Town & Country Planning Act 1990 (as amended)
Town and Country Planning (Development Management Procedure) (England) Order 2015
Application for approval of details reserved by condition imposed under planning application
EG/38/15/PL relating to condition No. 3 - Surface water drainage
97 Barnham Road Eastergate,,

Condition Number 3

Arun District Council have decided to **REFUSE details reserved by condition for the following reasons:**

Number
S17-03-01 E

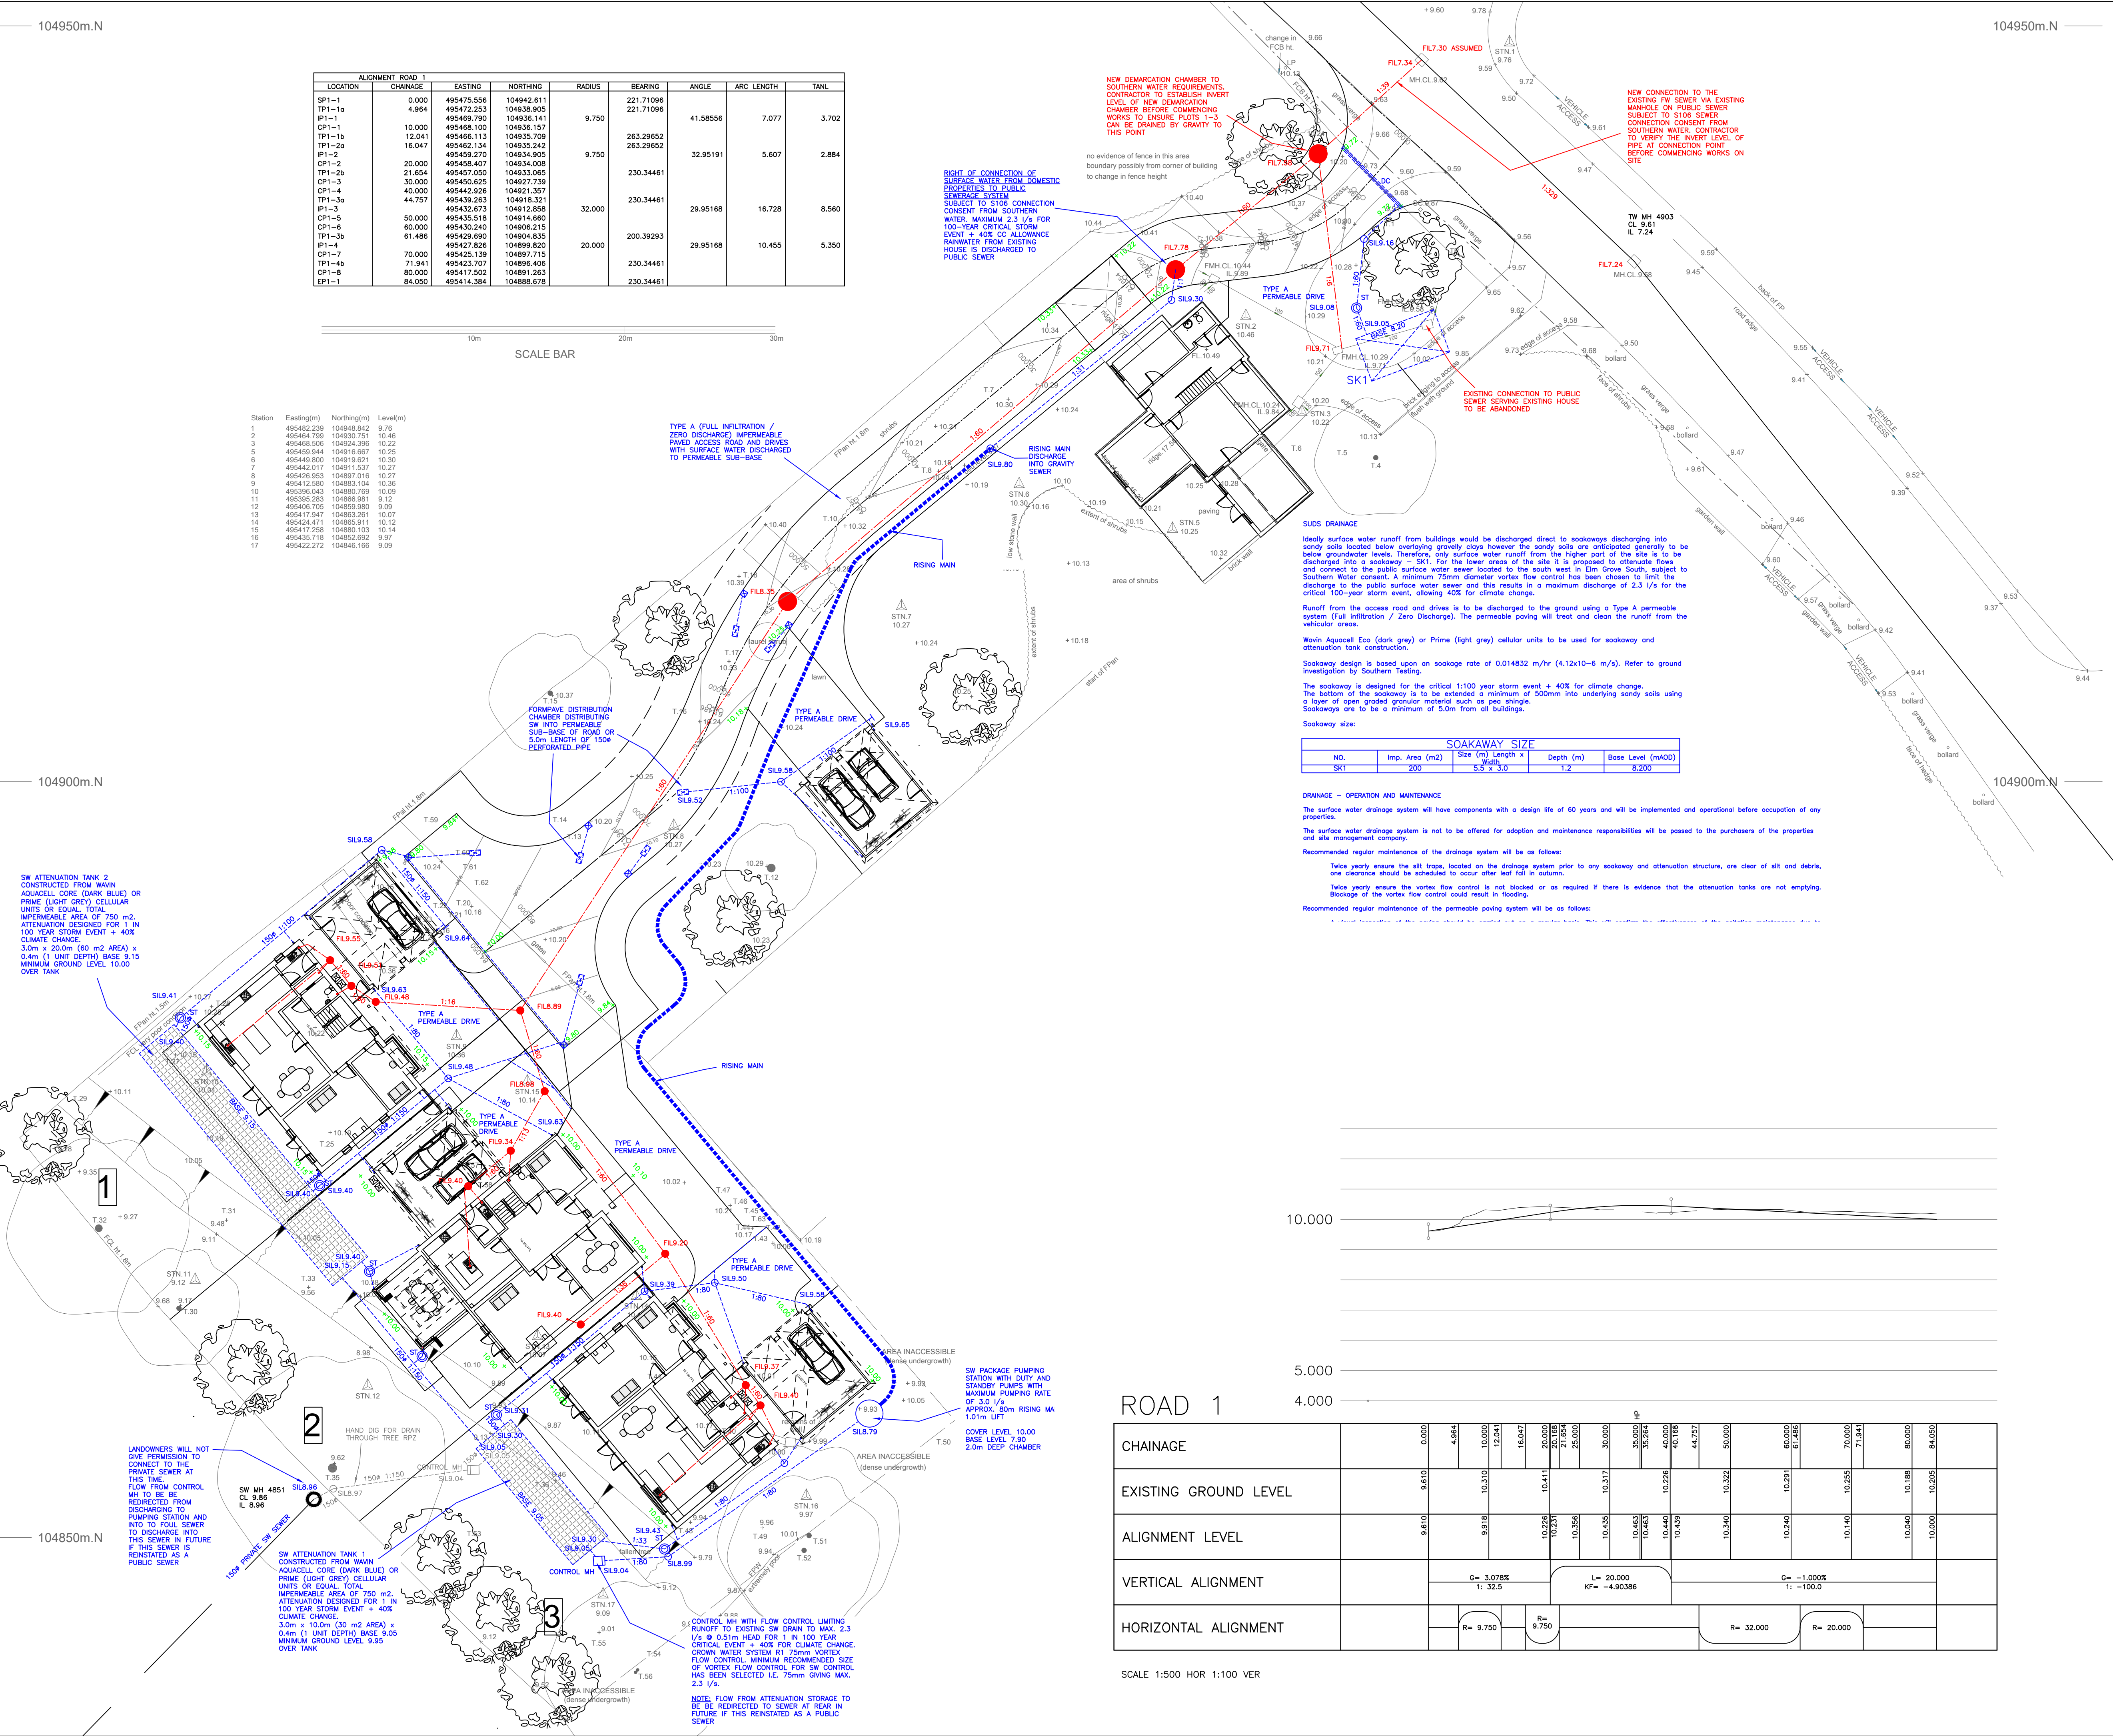
The Councils Drainage Engineers have raised an objection to the proposed discharge of surface water into the foul water sewer on the grounds that you have refused to include an additional manhole and length of gravity pipe (to be laid at an agreed gradient) at the downstream extent of the rising main.

These are required to slow down the flow from the surface water system into foul system so that flow velocity discrepancies between foul and surface water are far less. Therefore

reducing the risk of backing up, damage to the pipe, and blockages.
